Application number: 2025/93387	
What is the application for?:	Erection of poultry shed and fencing
Address of the site or building:	Bolster Moor Farm, Bolstermoor Road, Huddersfield, HD7 4JU
Postcode:	HD7 4JU

Type of comment: An objection	
Do you wish your comments to be published on the website anonymously?	Yes

FLOOR PLAN

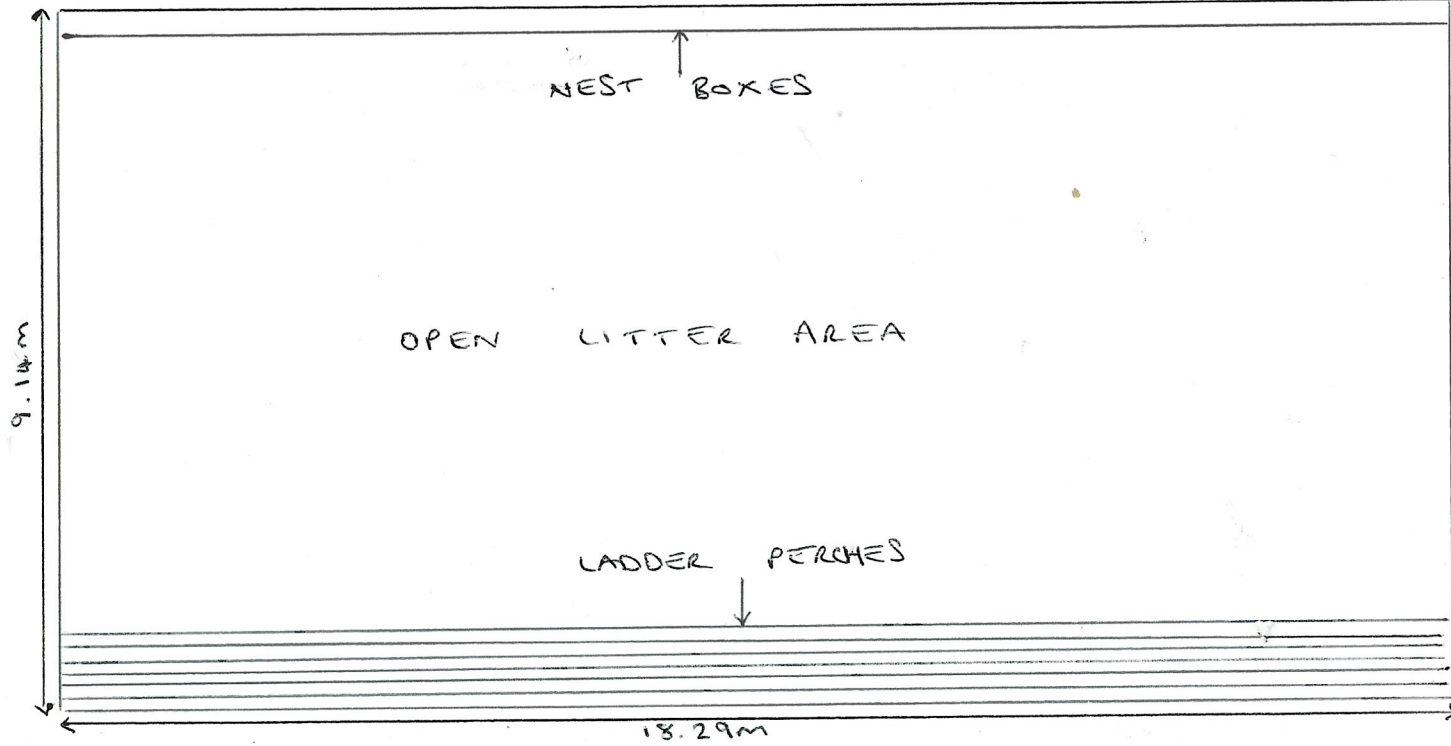
3. The design does not meet the requirements for commercial enterprises for egg production or farming livestock. ie; retention of contamination within the building both during egg production and periodic cleaning and decontamination due to the absence of solid floors and bunded access.

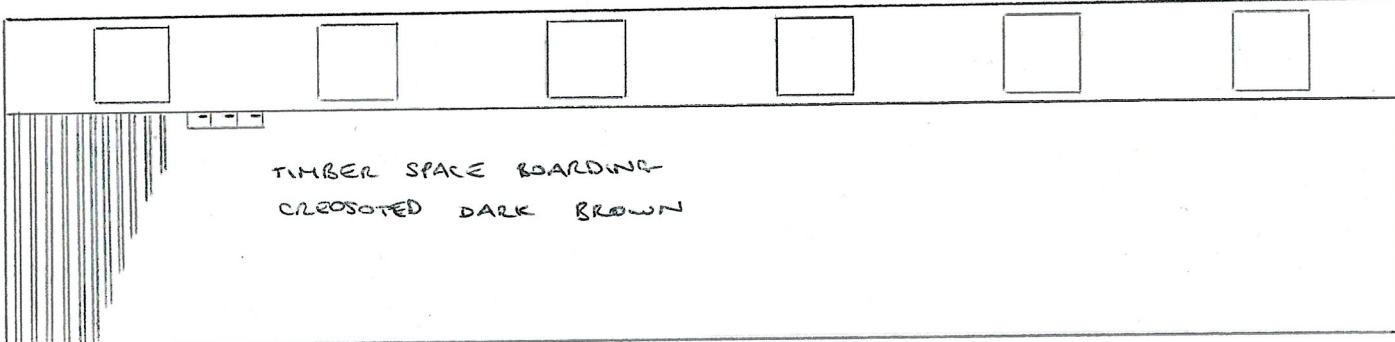
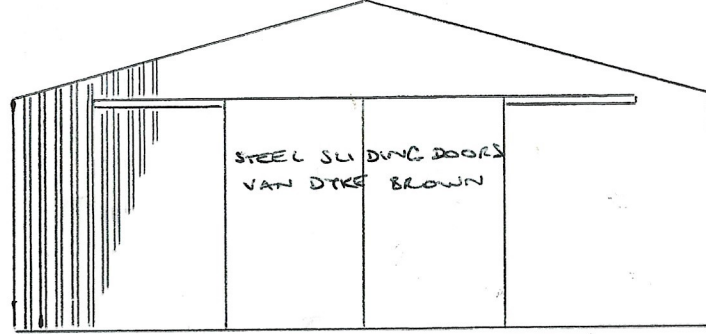
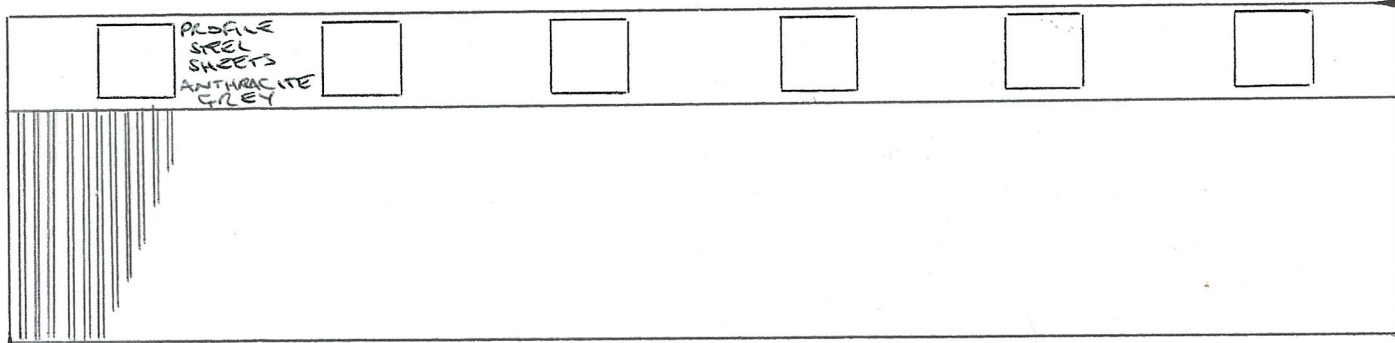
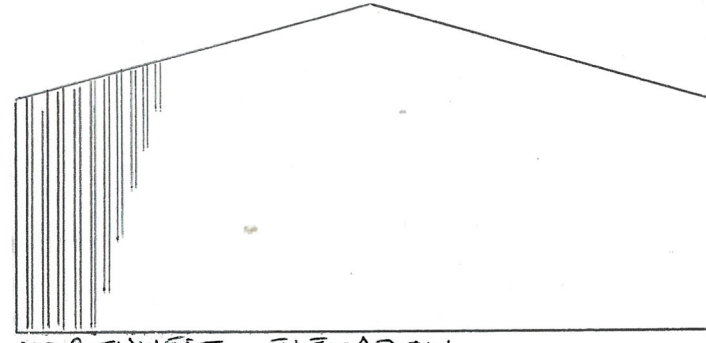
No means stated regarding dust control, the design indicates a hit and miss cladding design allowing the prevailing wind to blow through and also allows small birds to access the building thus compromising biosecurity.
